An
Coimisiún
Pleanála

Commission Order
ABP-320327-24

Planning Authority: Wicklow County Council

Planning Register Reference Number: EX53/2024

CLIENT	Tondo Ltd.			DATE	19-10-2022
JOB TITLE	Development at Kippure Estate				
LOCATION	Manor Kilbride, Blessington, Co. Wicklow				
STATUS	Pre-Planning	CHECKED	AB	SCALE	1:100@A1
DRAWN	NF	APPROVED	AB		
DRAWING No.	PL-03-01-KE	DRAWING TITLE	Structure 03	REVISION

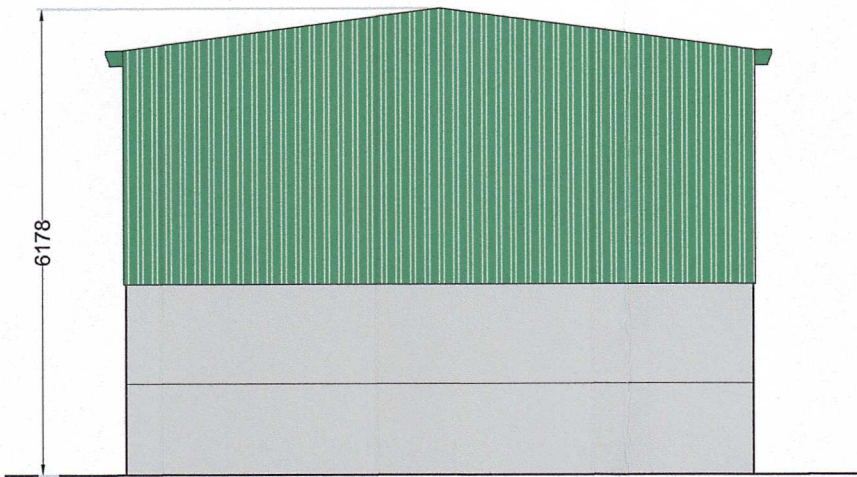
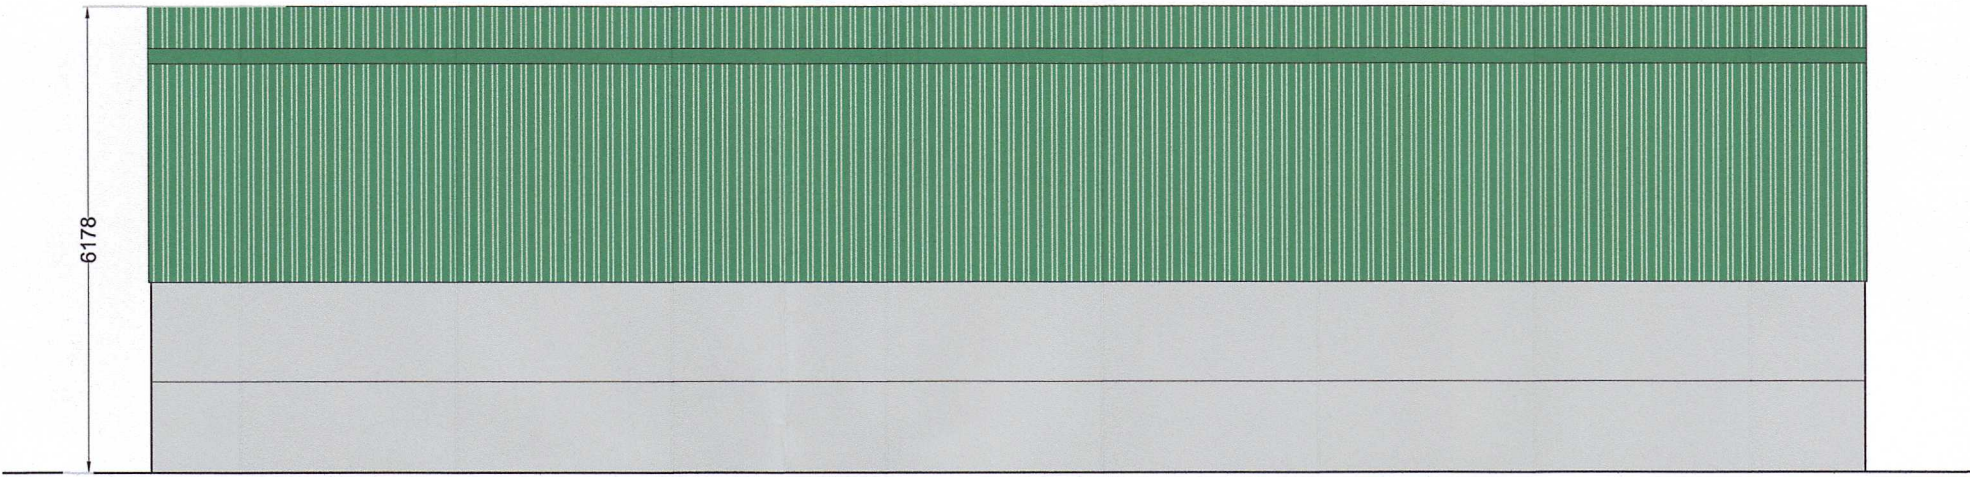
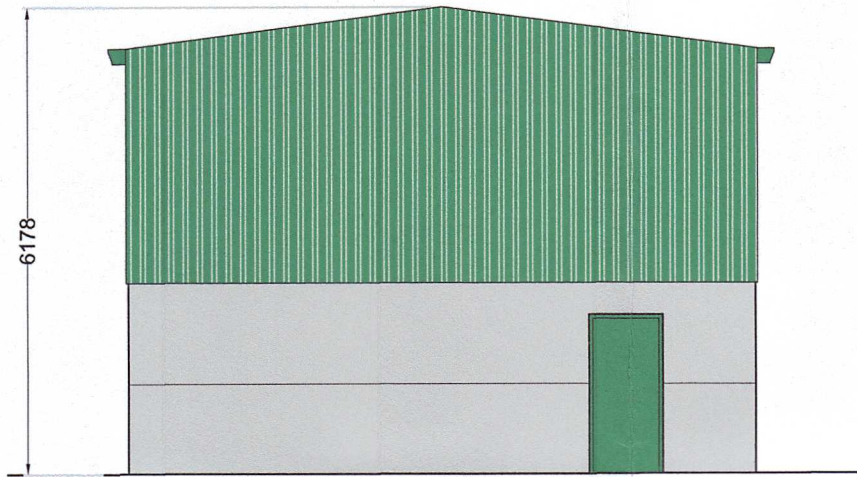
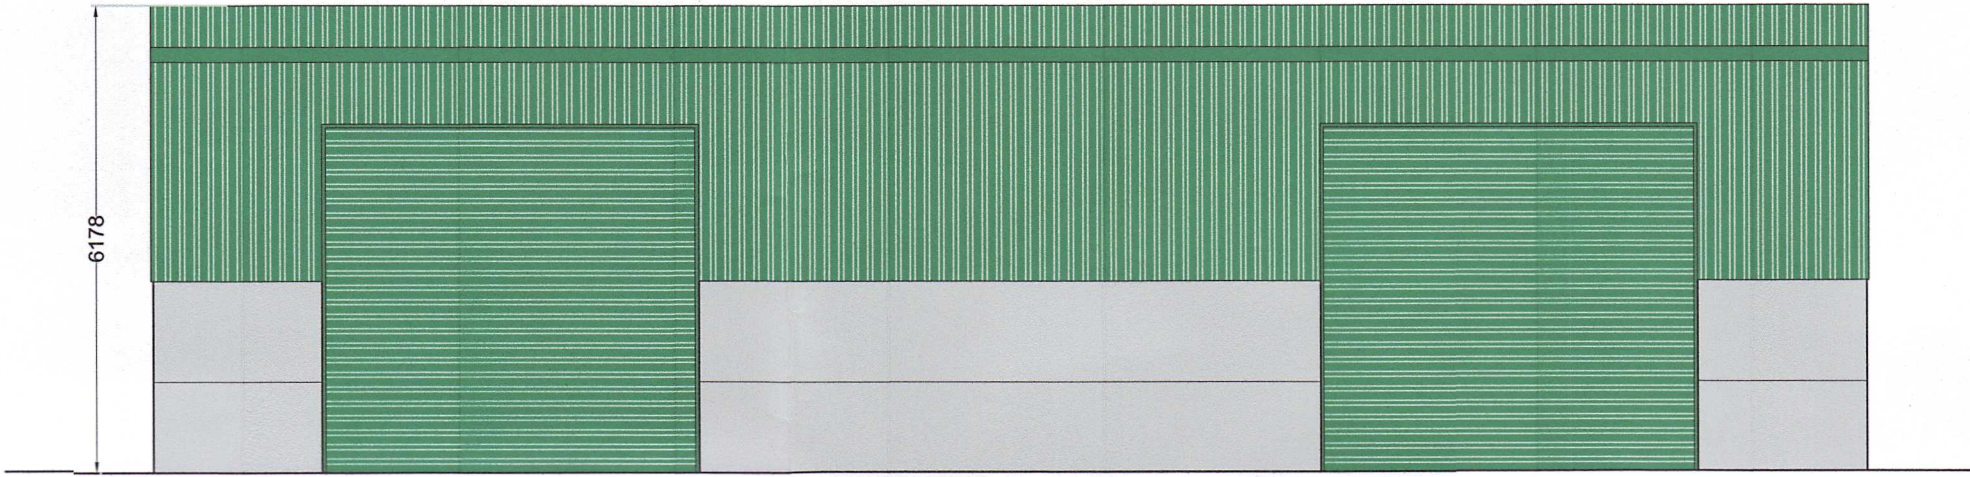
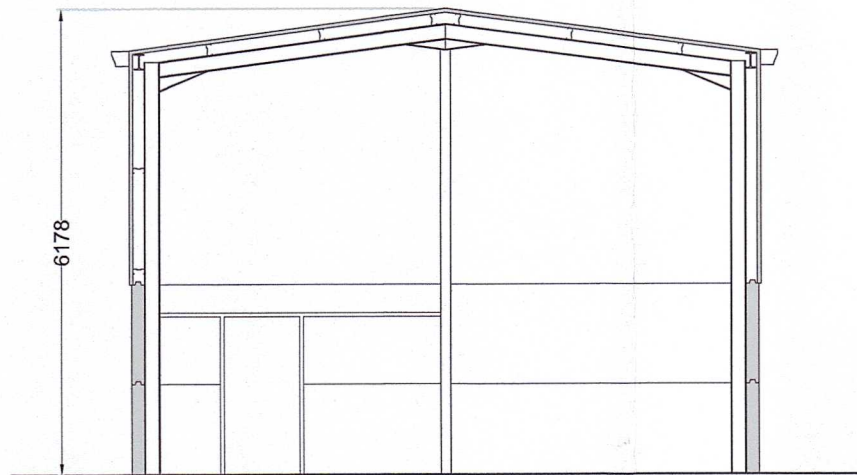
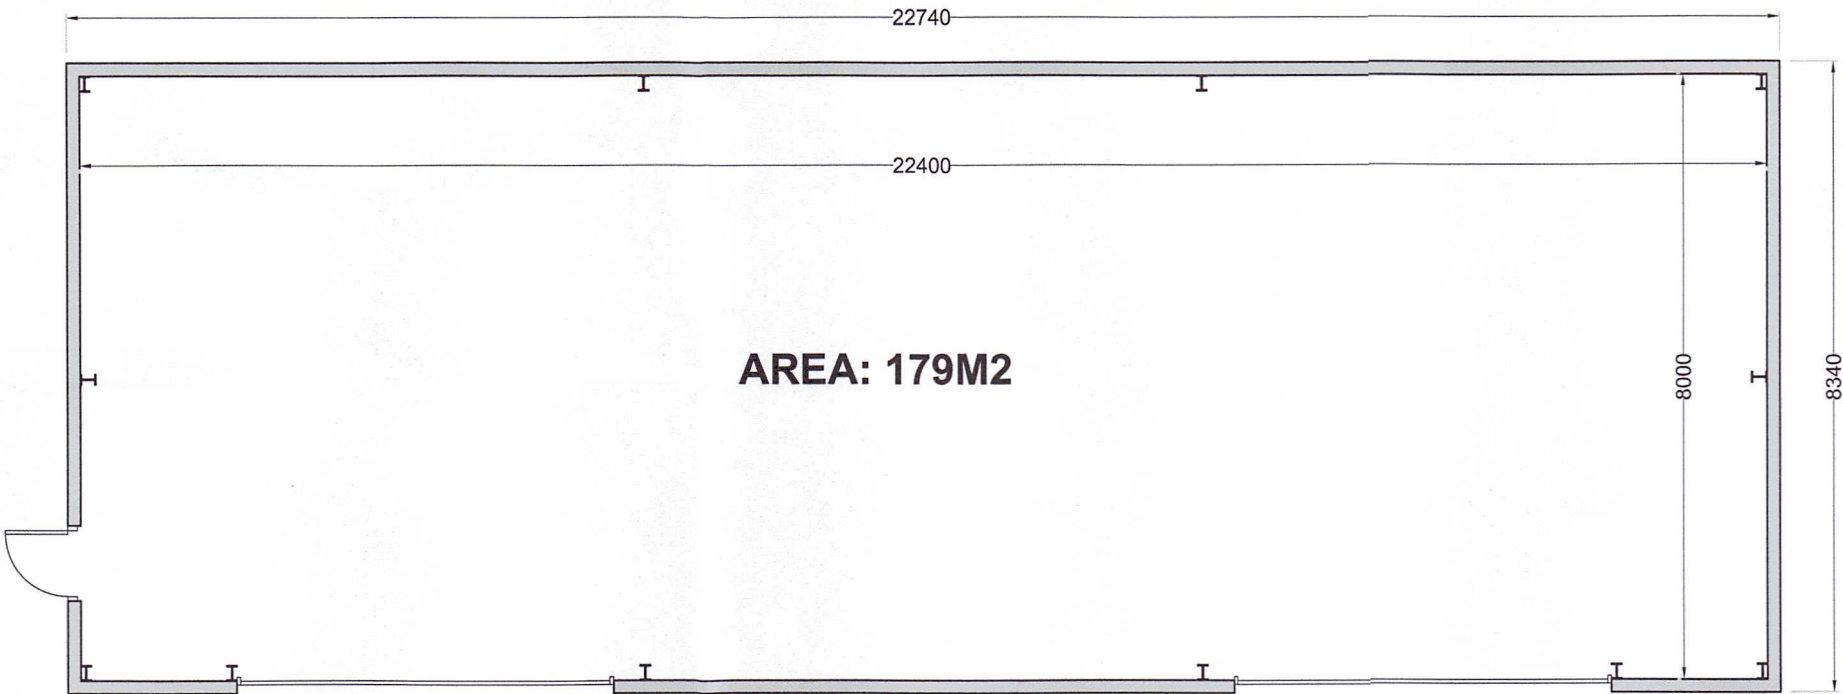
- (c) Structure Number 3: Detached agricultural maintenance/storage facility does not fall within the scope of Class 9 of Part 3 of Schedule 2 of the Planning and Development Regulations 2001, as amended, as the use of the structure for agriculture or forestry has not been adequately demonstrated. In addition, the aggregate gross floor space of the structure, with other such structures within 100 metres, exceeds the 900-square-metre limitation. Therefore, this structure does not constitute exempted development.

Structure 05

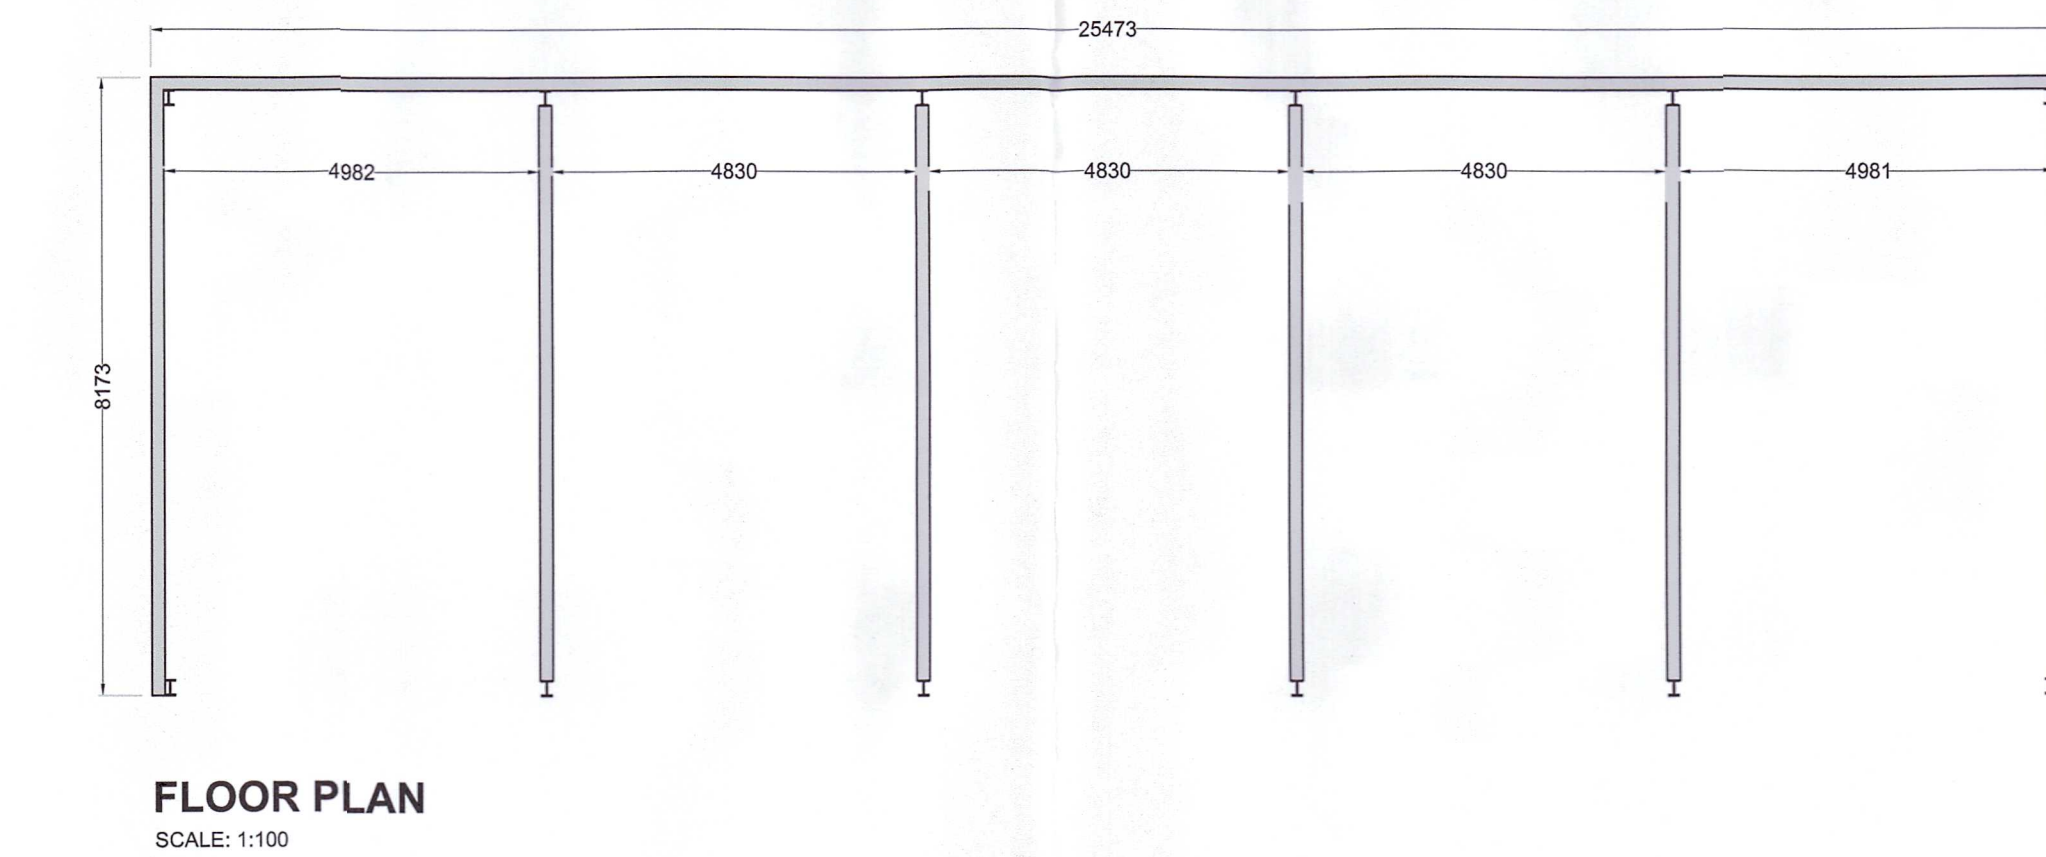
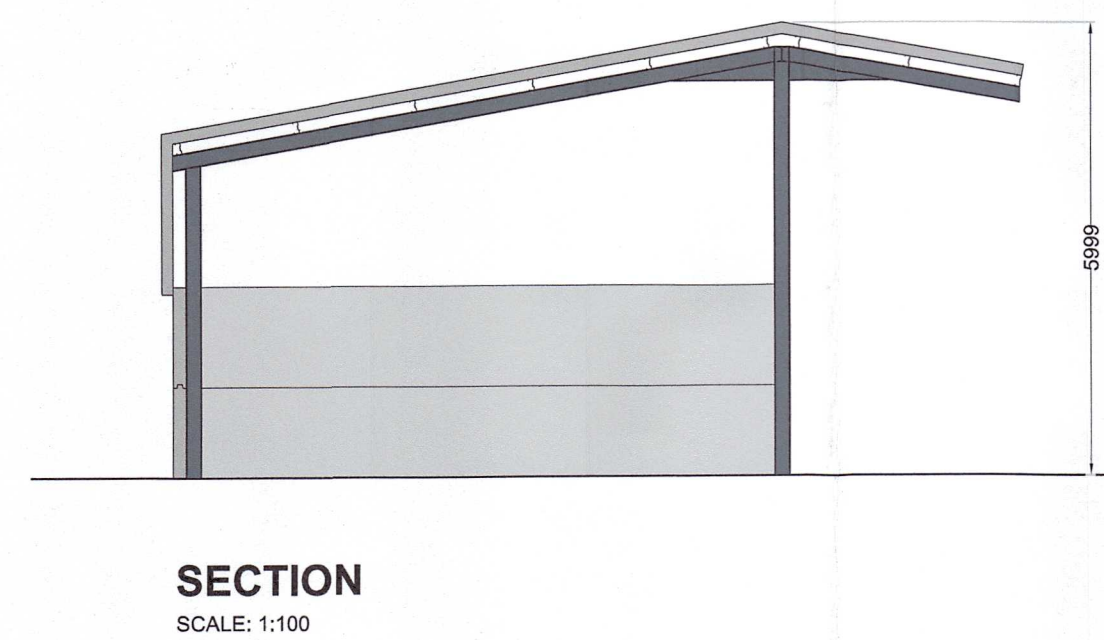
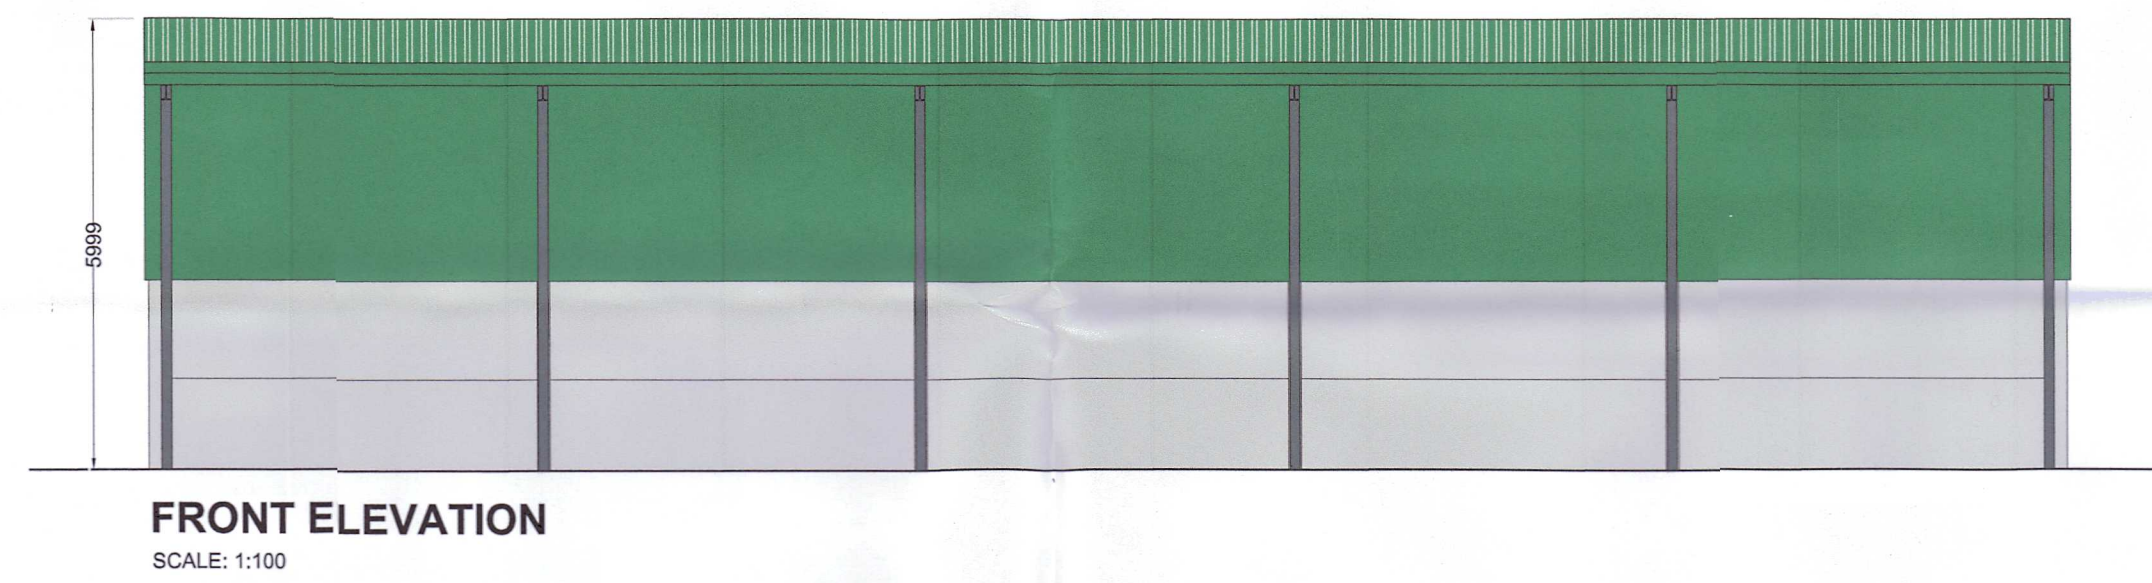
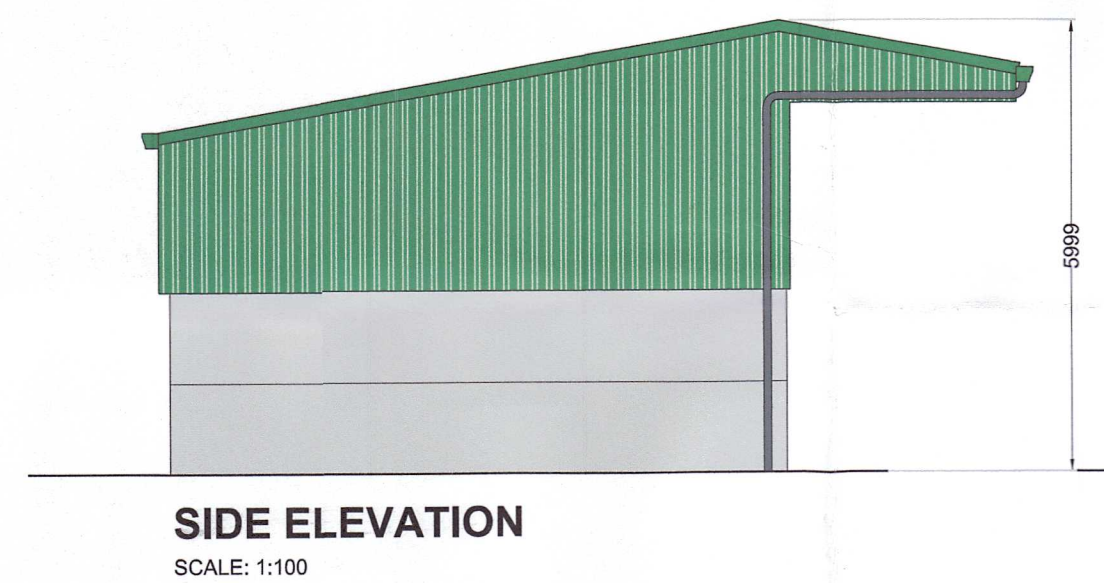
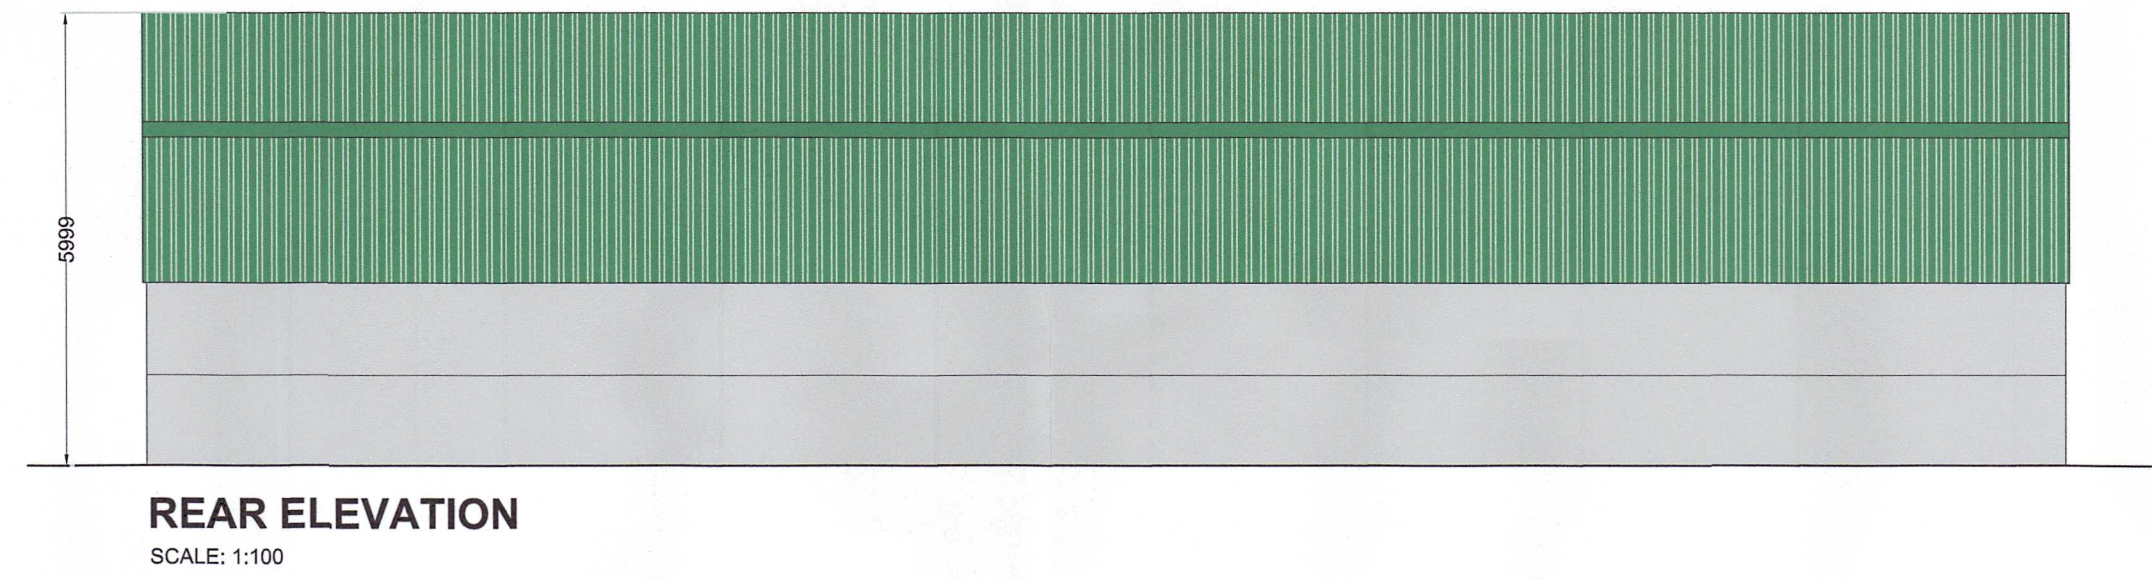
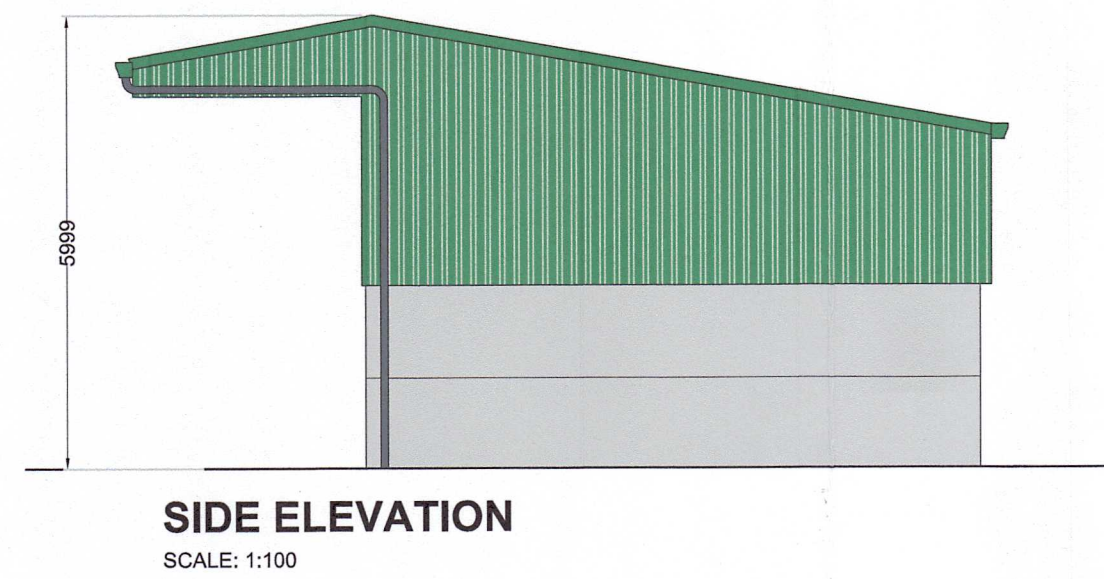
- (e) Structure Number 5: Open fronted agricultural shed does not fall within the scope of Class 9 of Part 3 of Schedule 2 of the Planning and Development Regulations 2001, as amended, as the use of the structure for agriculture or forestry has not been adequately demonstrated. In addition, the aggregate gross floor space of the structure, with other such structures within 100 metres, exceeds the 900-square-metre limitation. Therefore, this structure does not constitute exempted development.
